May 16, 2023

Re: PA22-024- Marysville 44th PRD – Technical Review 3
7315 / 7417 44th St NE – APN(s) 30053500303700 / 30053500303600

SUBJECT: 3rd Review Marysville 44 PRD, PA22-024

SUBJECT: PA 22-024 Marysville 44, Traffic Engineering Technical Review 3

DRAWING: C2
 SHEET: 2 OF 9

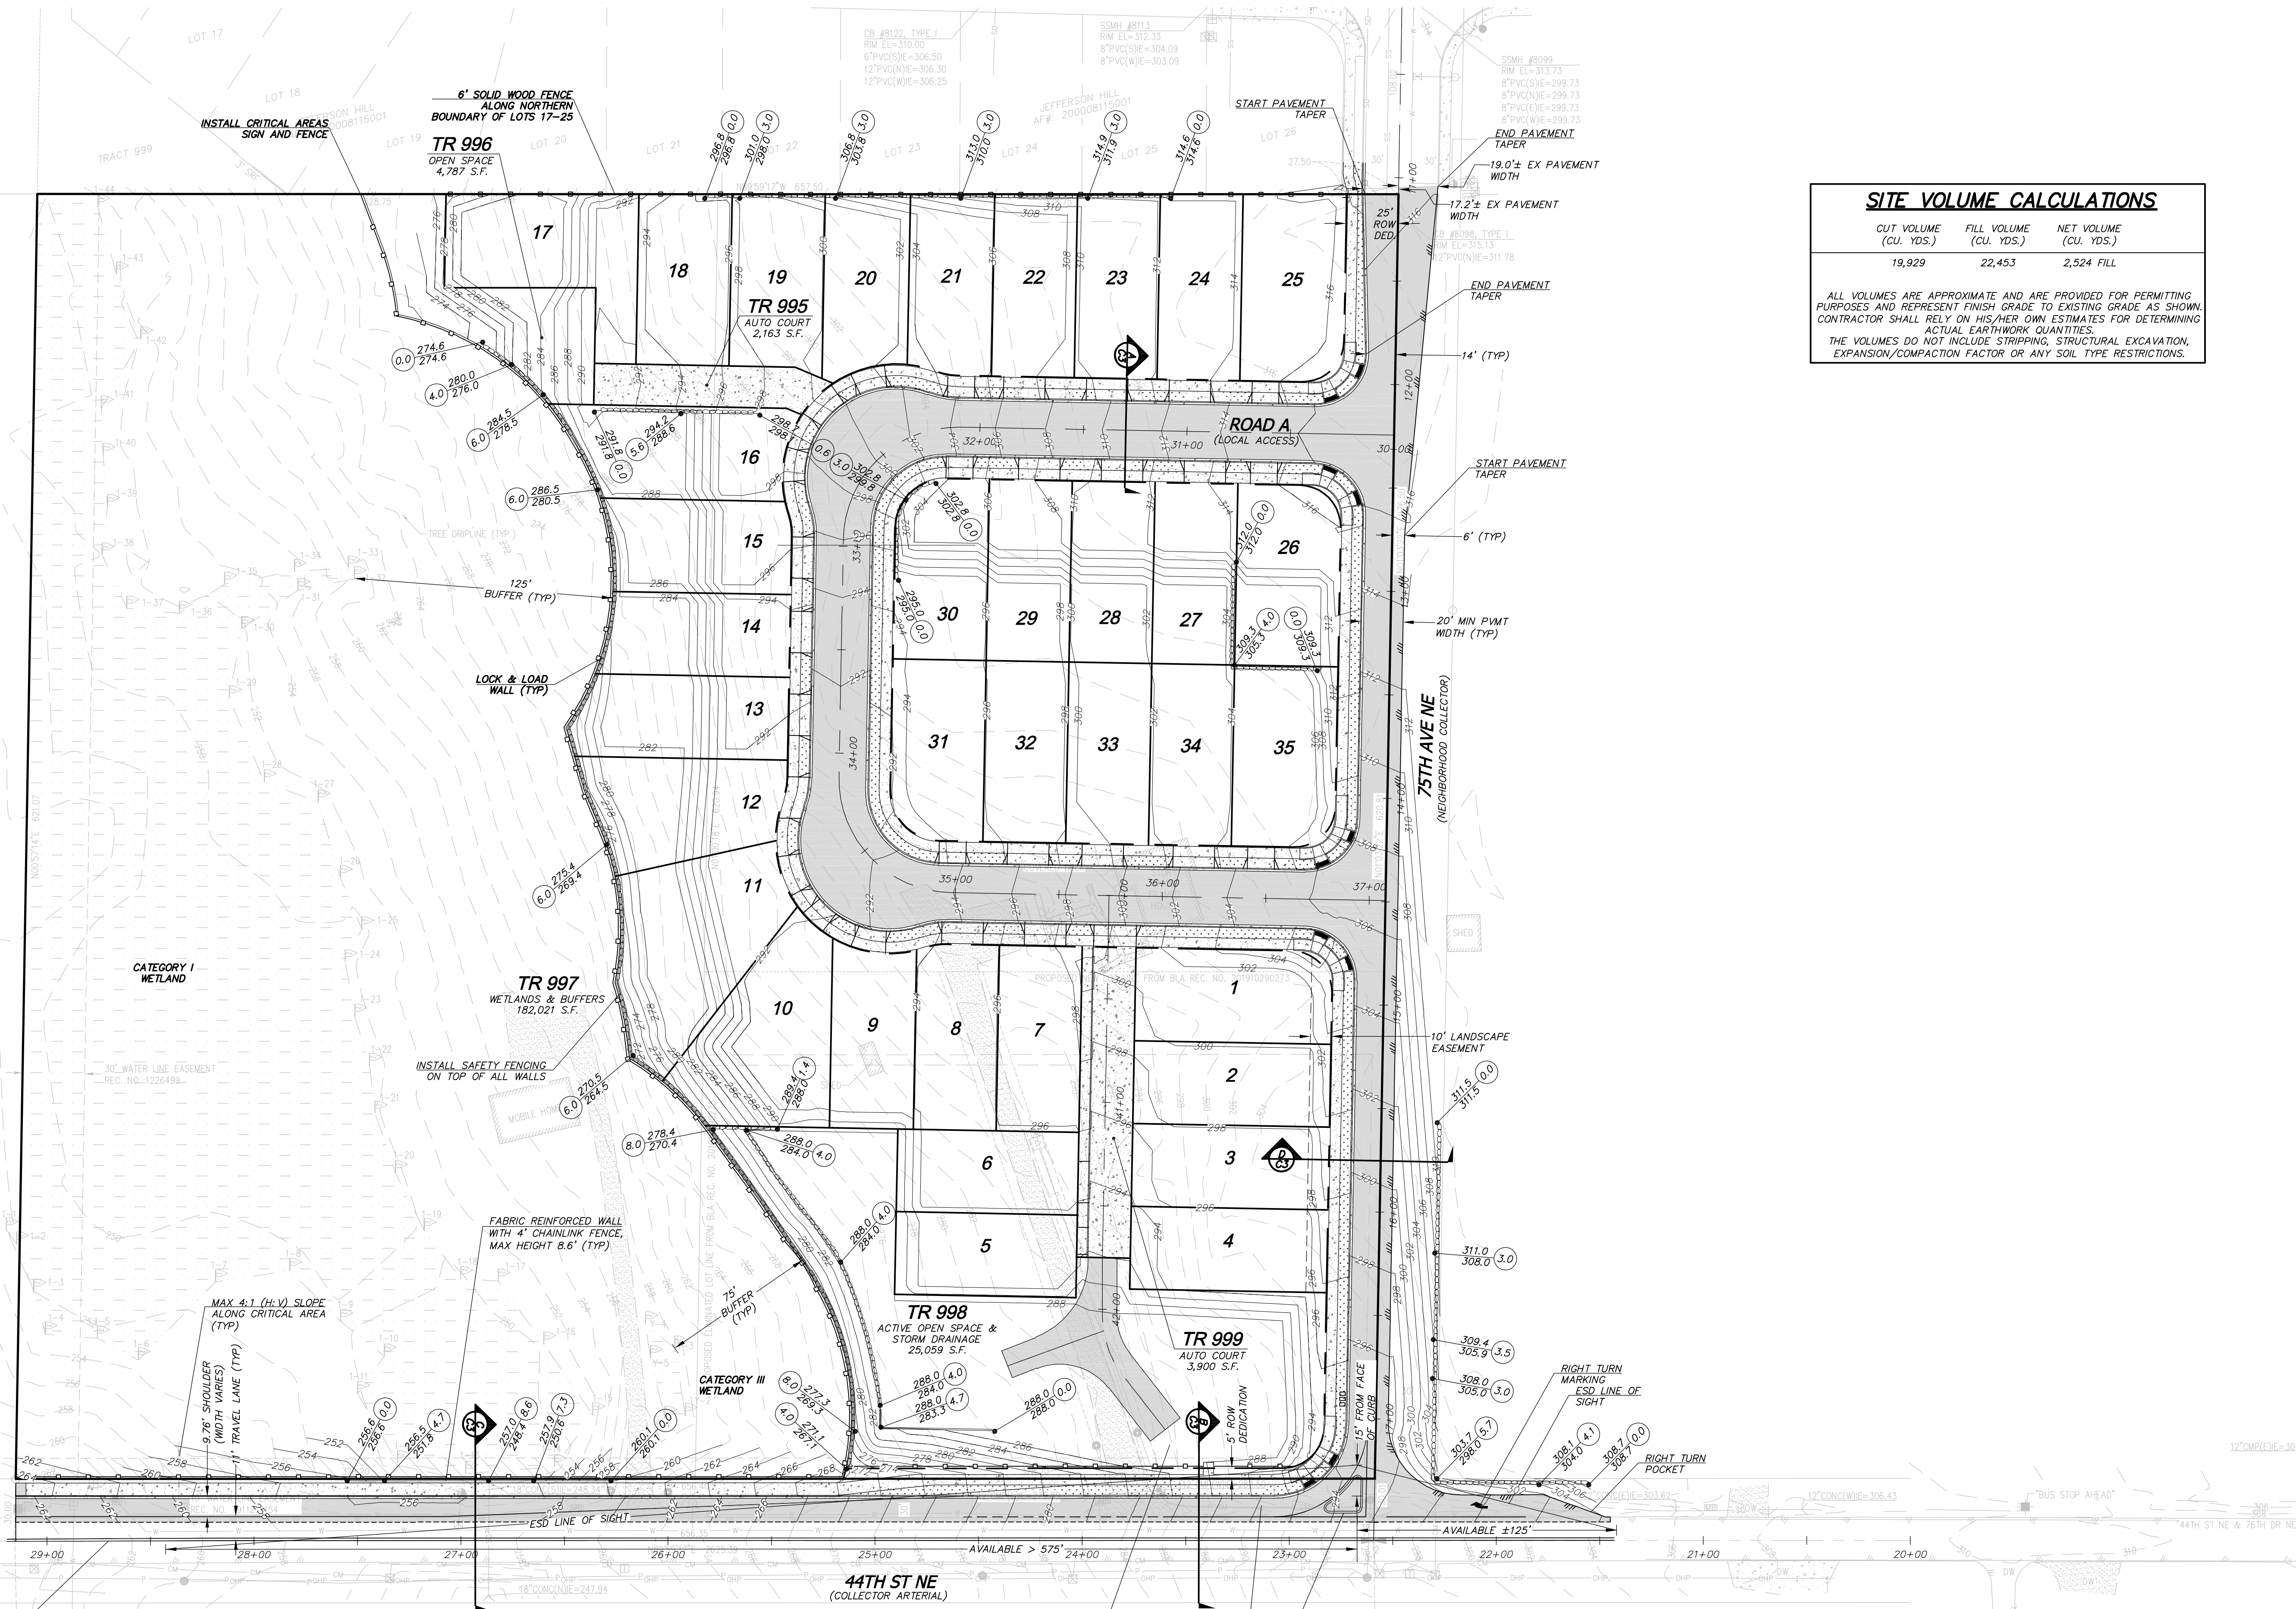
- a. The westbound right-turn deceleration lane on 44th St NE shall be consistent with WSDOT's Design Manual (DM) Exhibit 1310-21 to mitigate sight-distance. The multiplier for downgrade shall also be evaluated.

- b. The westbound acceleration lane on 44th St NE west of 75th Ave NE shall be consistent with WSDOT's DM Exhibit 1310-22. The northern 44th St NE curb line shall be shifted south as feasible to create a planter strip up to the width shown in EDDS Plan 3-201-007.

- i. The design speed for the southbound right-turn curve may be used to interpolate this lane length. The multiplier for downgrade shall also be evaluated. The taper rate in EDDS 3-406 should be used instead of 300'.

CONCEPTUAL ROAD PROFILES
 7315 & 7417 - 44TH ST NE
 MARYSVILLE, WA
 PARCELS 3005350030-3600,-3700

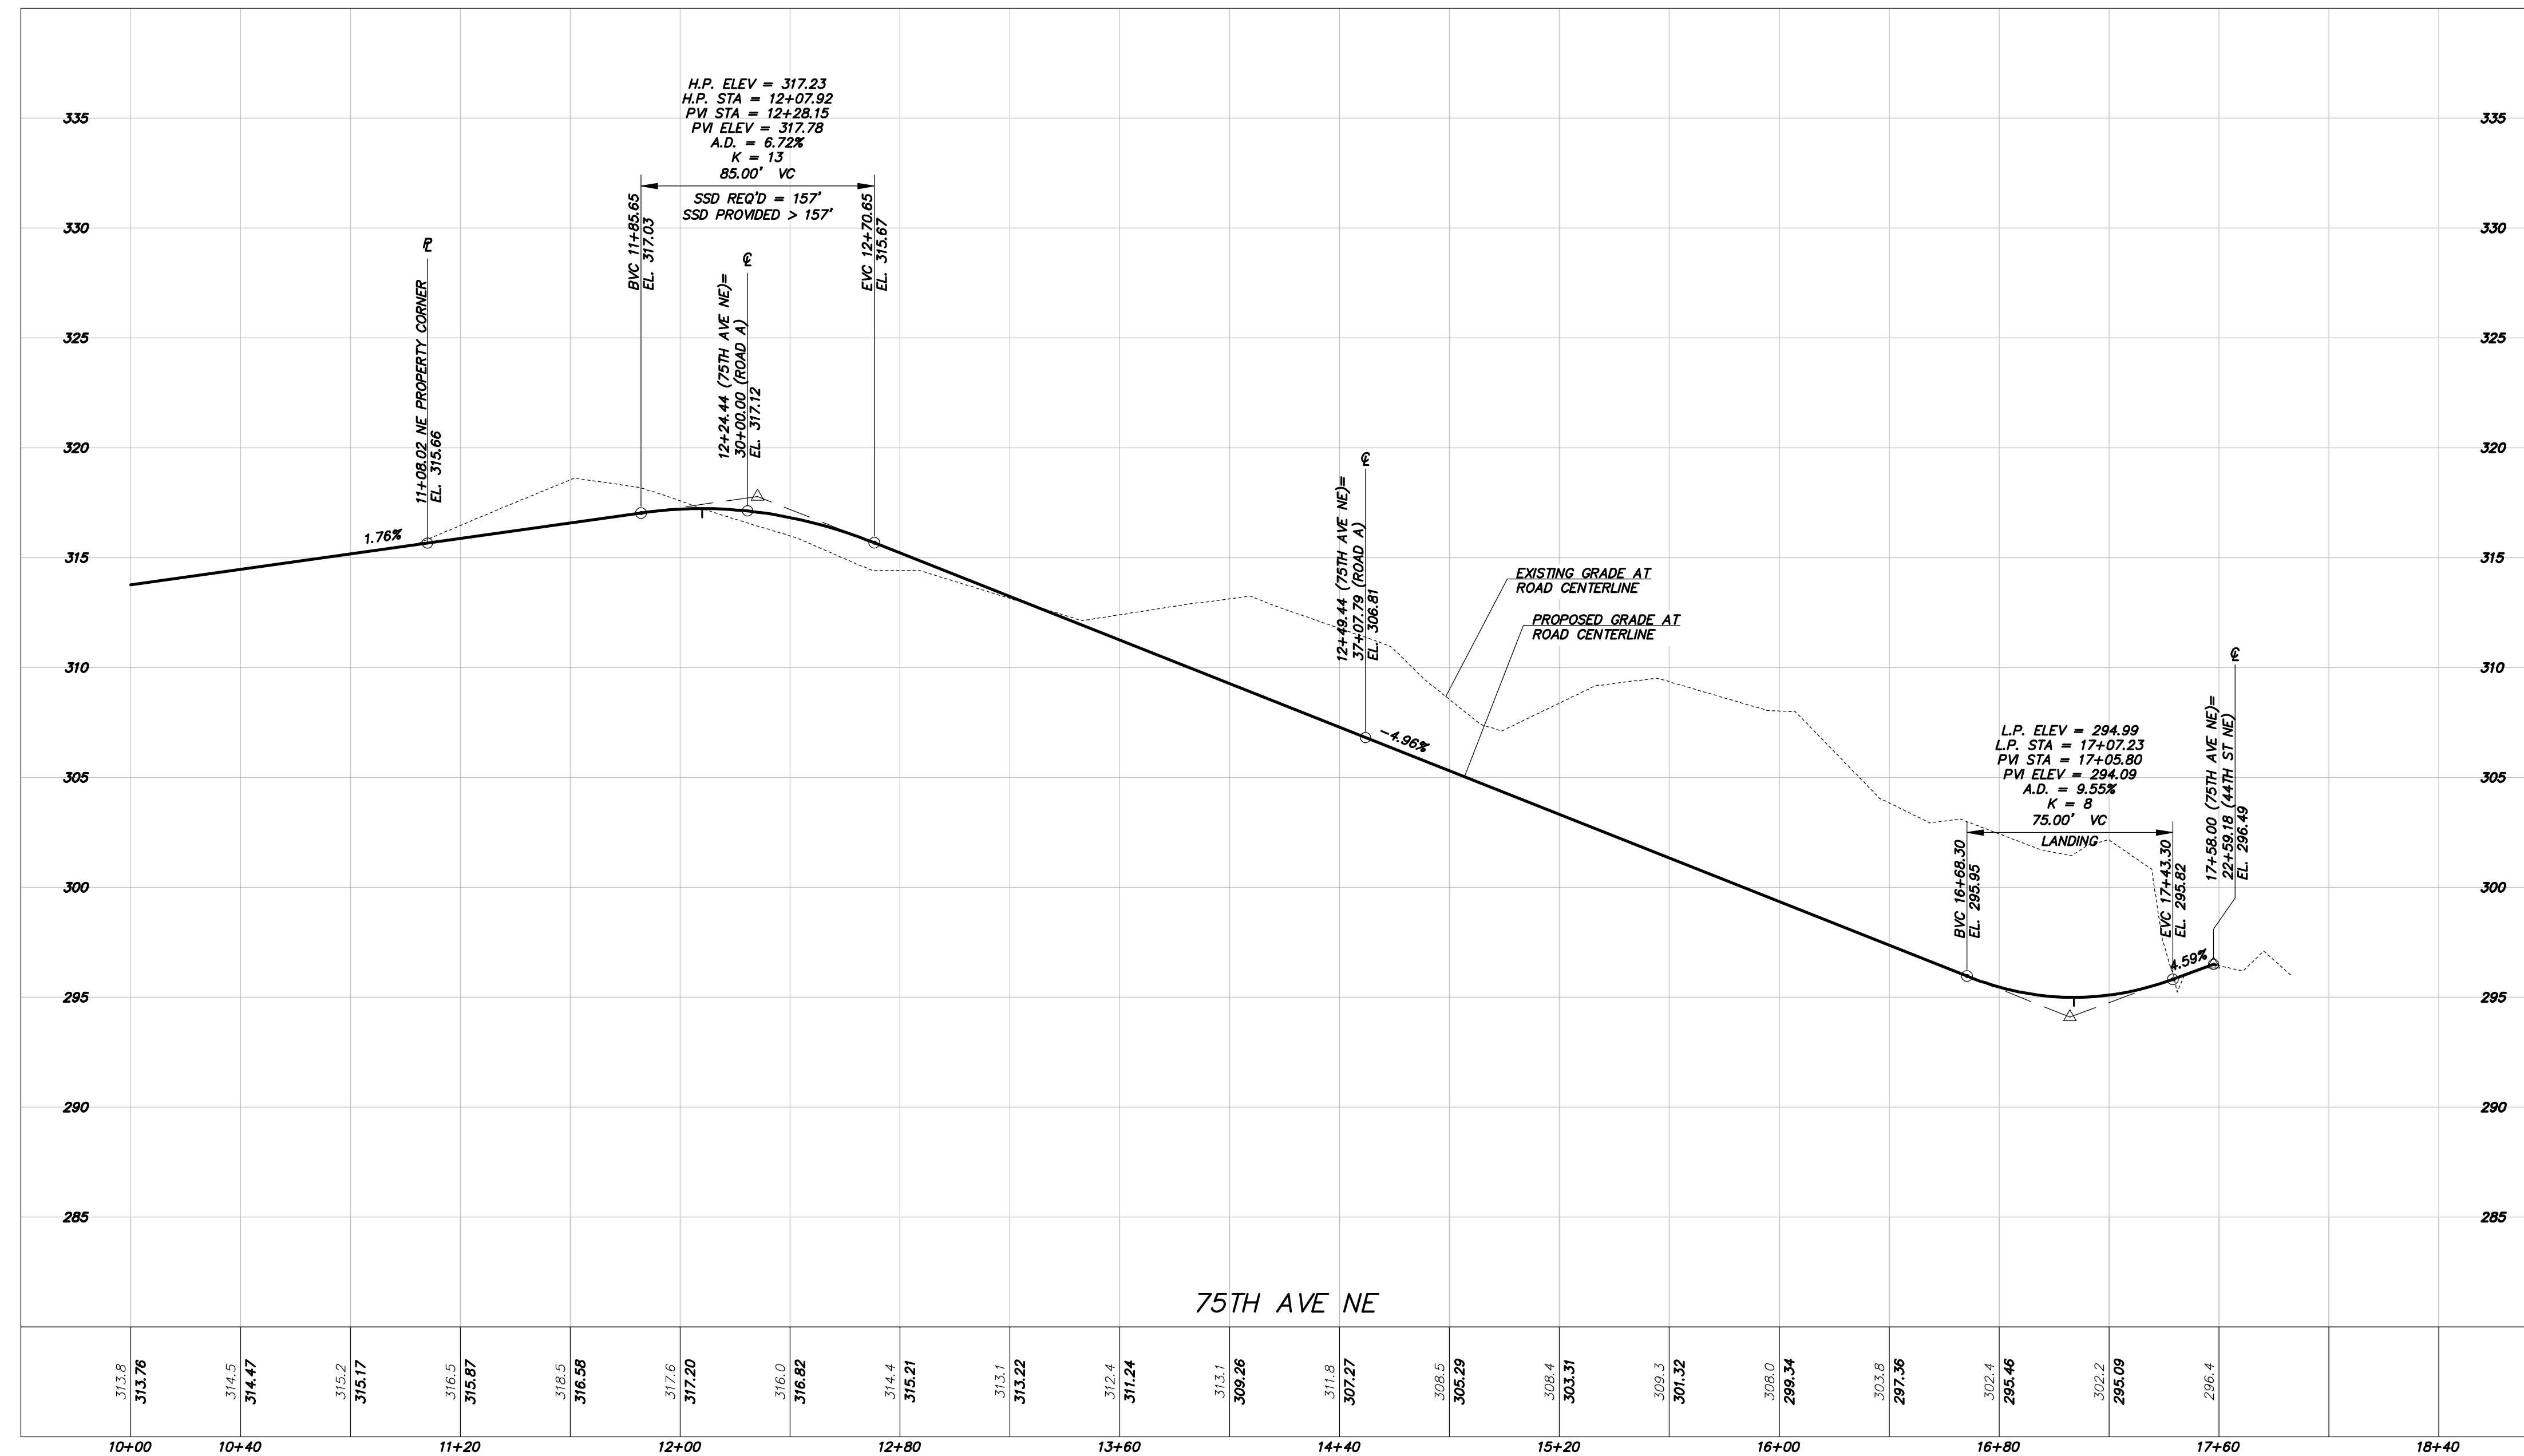
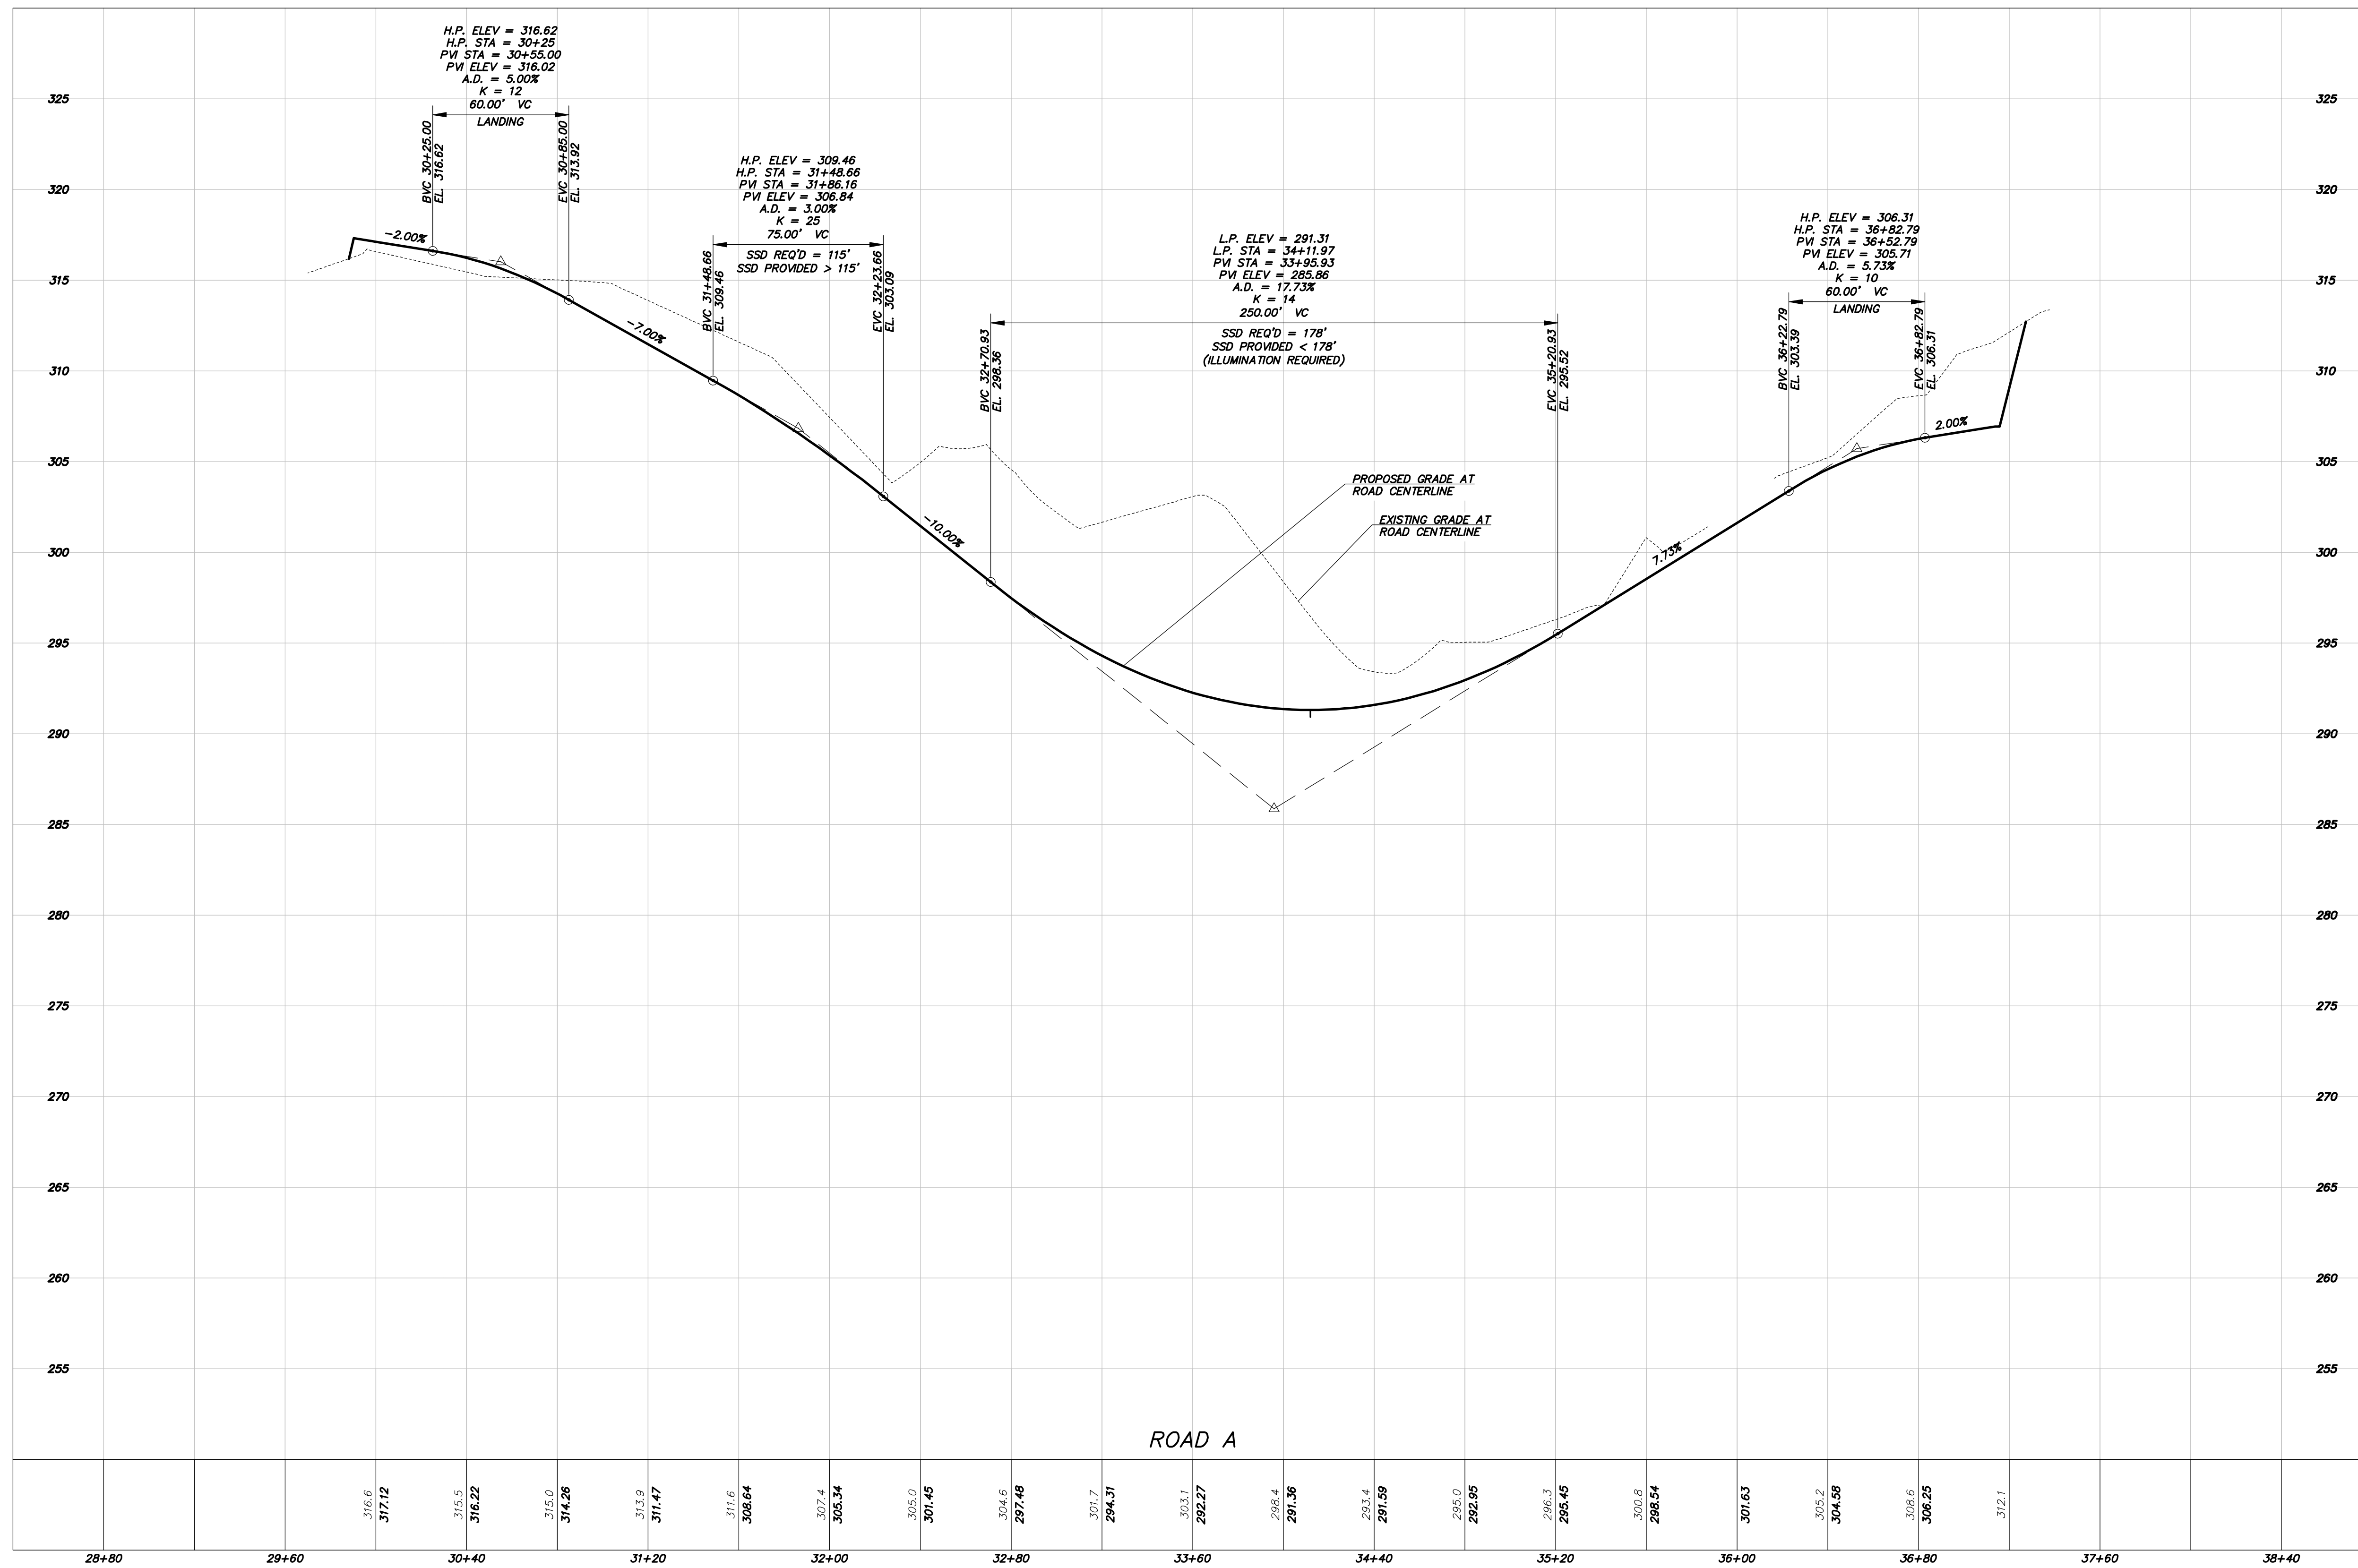
1. No water details shown, including size of water main;
2. Looking at road profiles air vacs will be necessary. Install in accordance with Design and Construction standards 2-070 part G;
3. Live tap on 44th Ave.
